Your Ref: 2023/91116

Our Ref: Z002461

20th February 2024

Land off Primrose Lane, Hightown, Liversedge – Erection of 77 dwellings, with access from Darley Road and associated works (Revised Description)

PRIMROSE LANE
 PROPOSED SITE LAYOUT

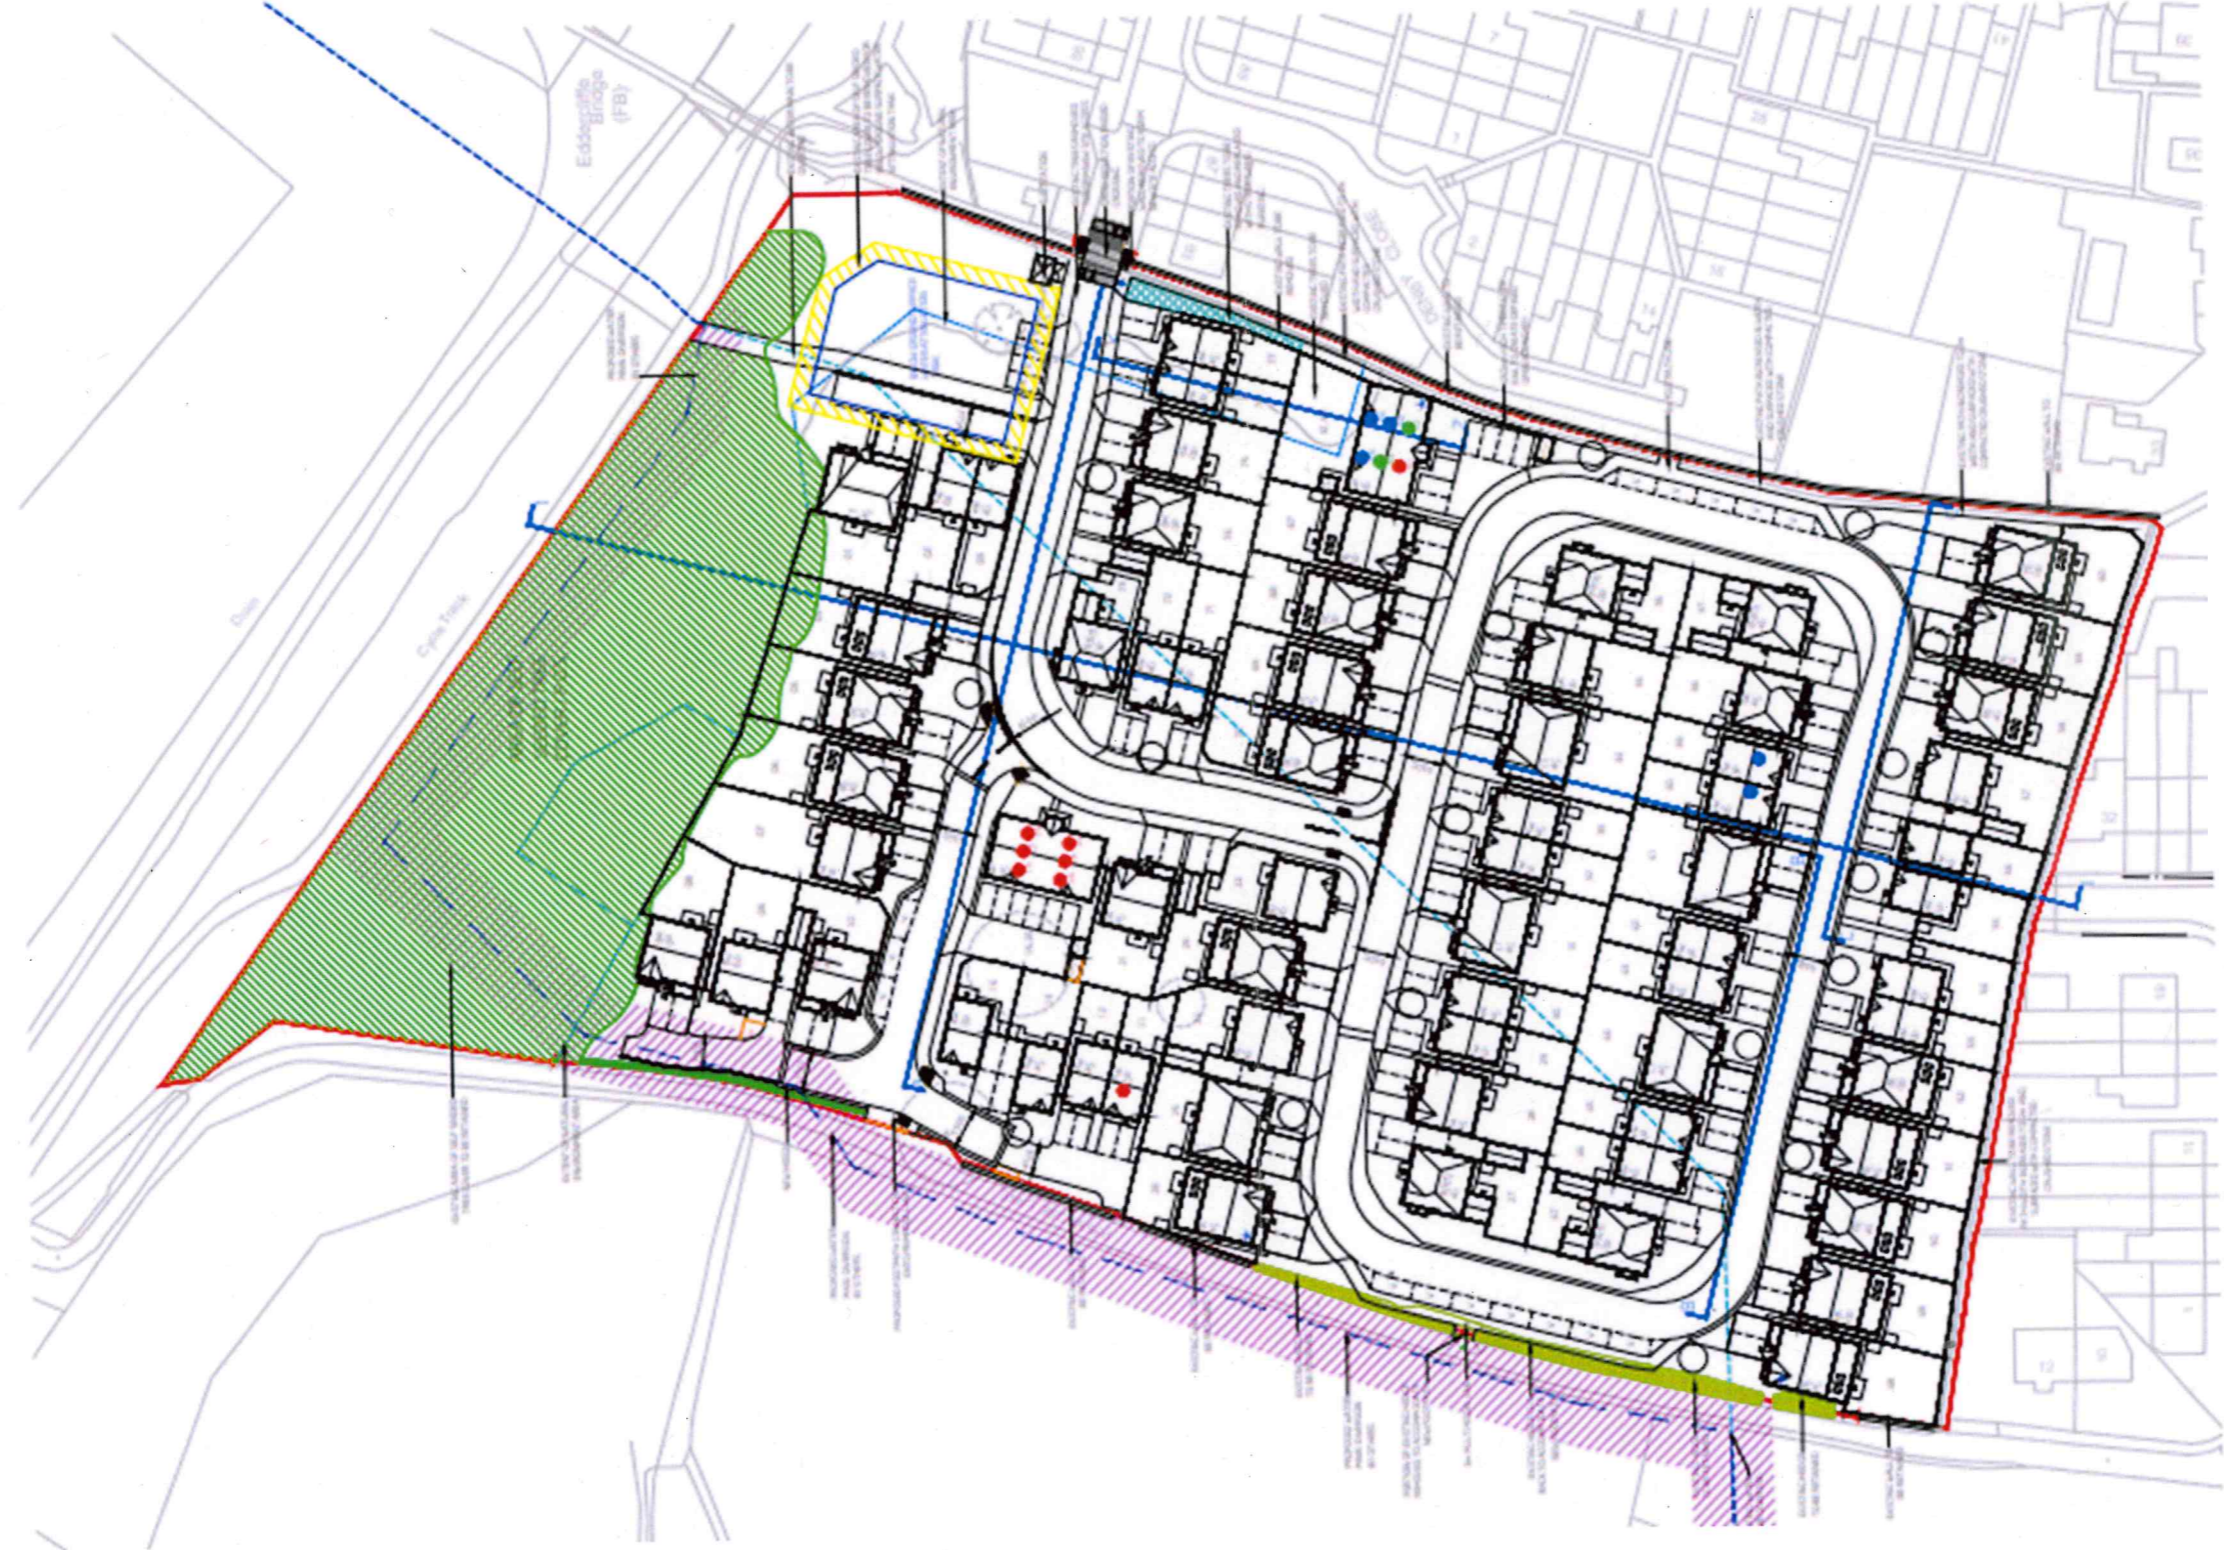
1.) The drainage and layout details submitted on drawing 'Proposed Site Layout' 3416-1-001 (revision DD) dated 26/01/24 that has been prepared by Niemen is not acceptable. The following point(s) should be addressed:

- a.) the submitted drawing appears to show proposed 'sewerage diversion by others' – there is not public sewerage on the site, also who are the 'others' referred too?
- b.) the submitted drawing should show the site-surveyed position of the public watermain crossing the site.
- c.) the submitted drawing should show the required watermain legal easement – or agreed alternate scheme

2.) On the Statutory Sewer Water main map, there is a 700mm diameter ductile Iron water main recorded to cross the site. It is essential that the presence of this infrastructure is taken into account in the design of the scheme.

a.) In this instance, a legal easement of 12 metres (6 metres either side) is required at each side of the sewer centre-line and it may not be acceptable to raise or lower ground levels over the sewer, nor to restrict access to the main.

b.) The mapped position of the watermain is indicative only and should be confirmed by on-site survey. Please contact tech.support.engineer.west@yorkshirewater.co.uk to arrange site survey.

c.) There should be no new tree planting within 6 metres of the public sewer.
